# Norfolk Vanguard Offshore Wind Farm

# Applicant's Comments

Applicant: Norfolk Vanguard Limited  
Document Reference: ExA; Comments; 10.D8.4  
Deadline 8  
Date: 30 May 2019

Figure: 29.14a	Drawing No: PB4476-004-029-014				
Revision:	Date:	Drawn:	Checked:	Size:	Scale:
04	15/05/2018	LA	JP	A3	Multiple
05	04/06/2018	LA	JP	A3	Multiple

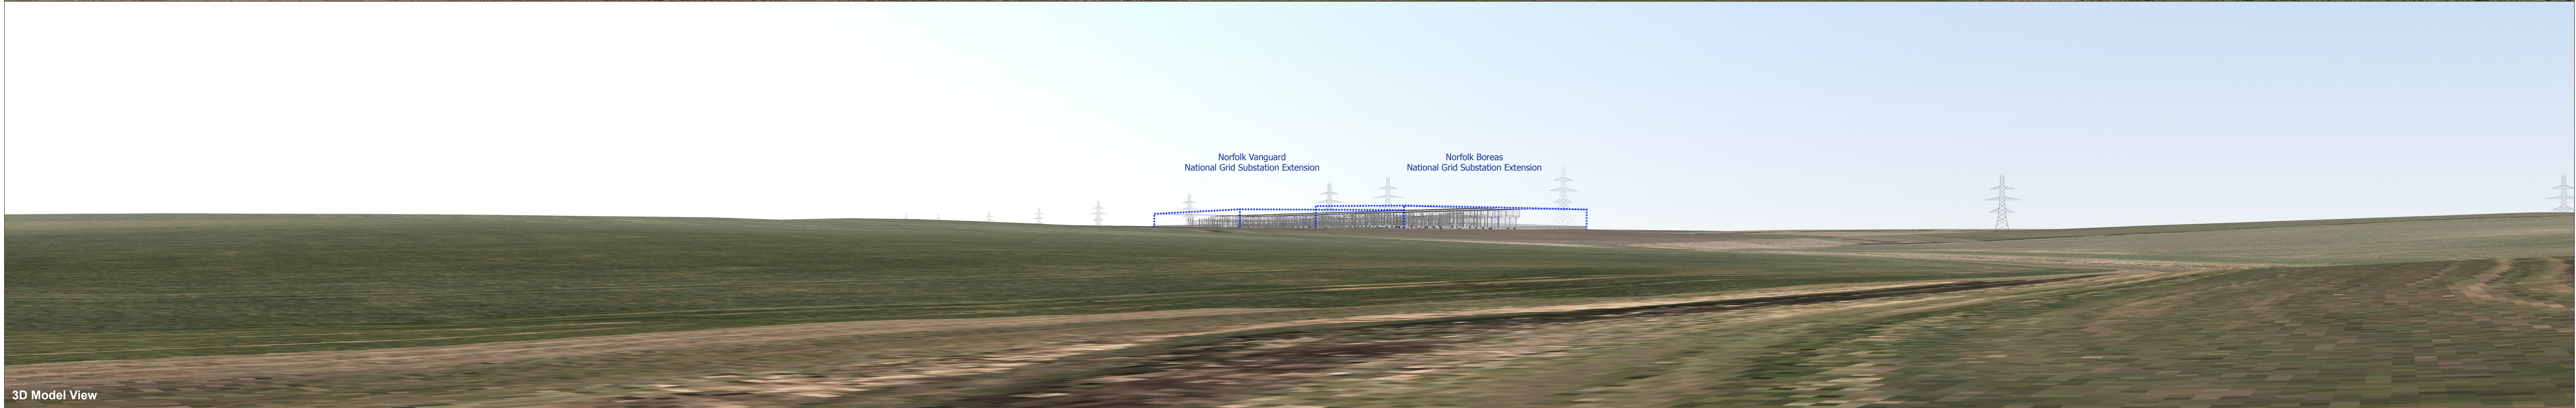
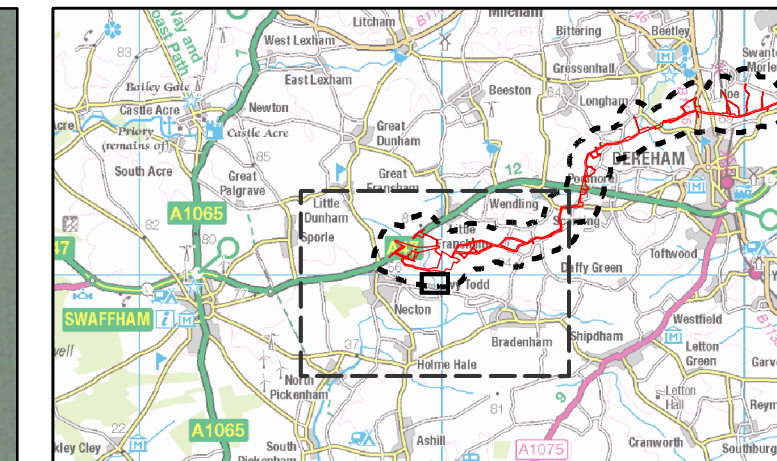
Written submission	Applicant's Response
<p>Viewpoint 2 Lodge Lane South scenario2. and viewpoint 3 Lodge Lane North scenario2 photomontages also concern me. Firstly they seem to be incorrectly titled Norfolk Boreas HVDC Substation, when they are I hope Norfolk Vanguard. Then comparing the views provided reveals an inconsistency that has a massive effect on the end result. Starting with the lowest viewpoint, 2 Lodge Lane South, at stream level, at the ford, both converter halls are clearly visible. Then move to viewpoint 3 Lodge Lane North, which is up a considerable gradient, and closer to the Halls, and the east hall is barely visible, hidden behind a virtual 3D mound. On the same page as the 3D image, the baseline photograph does not show this mound, but the land consistently falling away from the lane.</p> <p>The baseline photograph looks correct, and the 3D image looks faulty. If the 3D images only are compared, starting again with viewpoint 2, the lane and gradient which you travel along to view point 3 is clear, and it is clear that viewpoint 3 would be a better vantage point to see the halls more completely and in more detail, but when you arrive at 3D image viewpoint 3. the land behind Lodge Farm has dropped 10m, and a mound has formed to the left of the lane, both features make the view of the halls worse than viewpoint 2. and are nonexistent, and do not manifest as you travel up Lodge Lane. The subsequent mitigation montage looks based on the 3D image, which shows it seriously over effective, also taking into account the land rises 4-5m behind Lodge Farm, the 3D image looks, or is totally wrong, for whatever reason.</p>	<p>Figure 29.14a and 29.15a show both the Norfolk Vanguard and Norfolk Boreas onshore project substations and Necton National Grid substation extensions. Norfolk Boreas infrastructure is noted in the key as different colours to the Norfolk Vanguard infrastructure (red 'Onshore project substation' and orange 'National Grid substation extension', while Norfolk Boreas is shown as pale pink and dark pink, respectively). The photomontages which follow these diagrams also show both project infrastructure from each viewpoint.</p> <p>The 3D model is based on actual land height, and so has the same contours and land heights as the baseline photograph. However, photomontages were also created to show a more accurate representation of the visibility of the onshore infrastructure. This is shown in Figure 29.14c and 29.14d (for Viewpoint 2 with and without mitigation planting) and Figure 29.15c and 29.15d (for Viewpoint 3 with and without mitigation planting).</p> <p>A second suite of visualisations were produced at Deadline 3, at the request of the Examining Authority, to show a 19m Rochdale Envelope (shown as a dashed box) around the depiction of the substation, to indicate the height of the tallest building (document reference: ExA; ISH; 10.D3.1G).</p>
